**RE: Harnett County Land Use Application # 07-5-18251**

The Harnett County Department of Public Health, Environmental Health Division on August 21, 2007 evaluated the above referenced property at the site designated on the plat/site plan that accompanied your existing tank application. According to your application requesting a home addition, the evaluation was done in accordance with the laws and rules governing wastewater systems in North Carolina General Statute 18A.1950 including related statutes and Title 15A, Subchapter 18A, of the North Carolina Administrative Code, Rule.1950 and related rules.

Based on the criteria set out in Title 15A, Subchapter 18A, of the North Carolina Administrative Code, Rules .1950, the evaluation indicated that the site is **UNSUITABLE** for the addition requested. Therefore, your request for an existing tank is **DENIED**. The site is denied based on the following:

Harnett County Department of Public Health Site Sketch

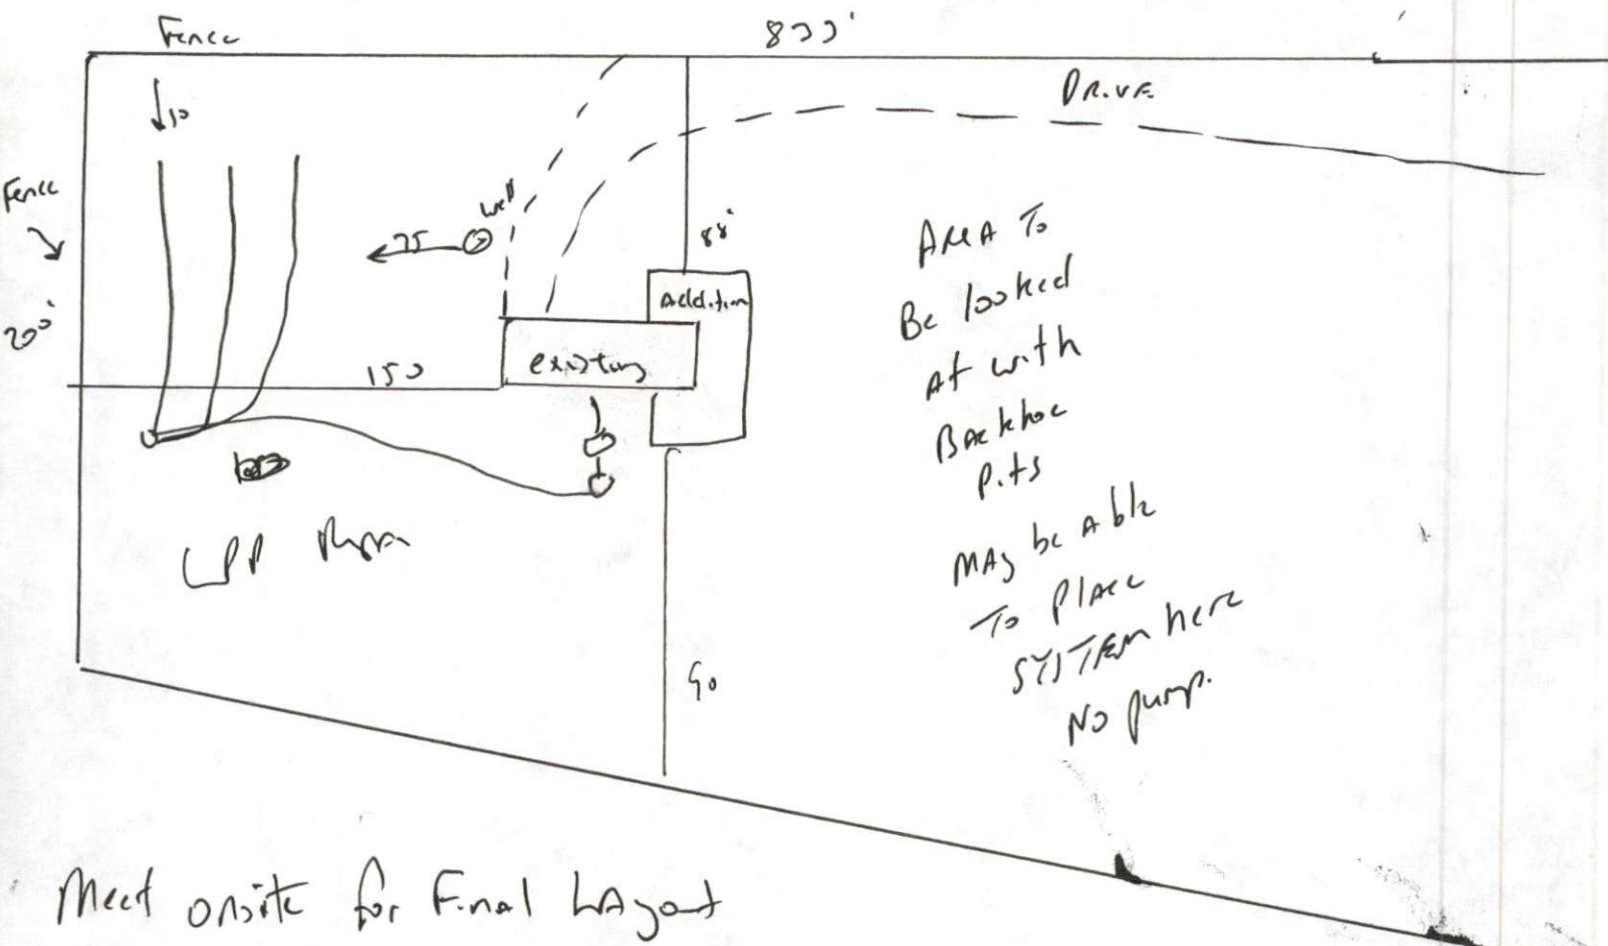
- 15A NCAC 18A.1950 a(16) Any swimming pool must be 15' from any part of septic system.
- 15A NCAC 18.1945 (b) Each lot shall have original septic system plus repair area.
- 15A NCAC 18A.1950 (10) – Any building to be 5' from drain line.  
*(Can not drive or park on septic system)*

*Your proposed addition to the home would be on top of your existing septic system. We cannot allow you to build on top of your septic system or repair area. You can not drive or park on top of septic system either. Your options are:*

*#1 - Change the addition to the home so that the addition is not being built on top of drain field or being driven on.*

*#2 - Apply for a new soil evaluation to see if the septic system and repair area may be relocated to accommodate the addition.*
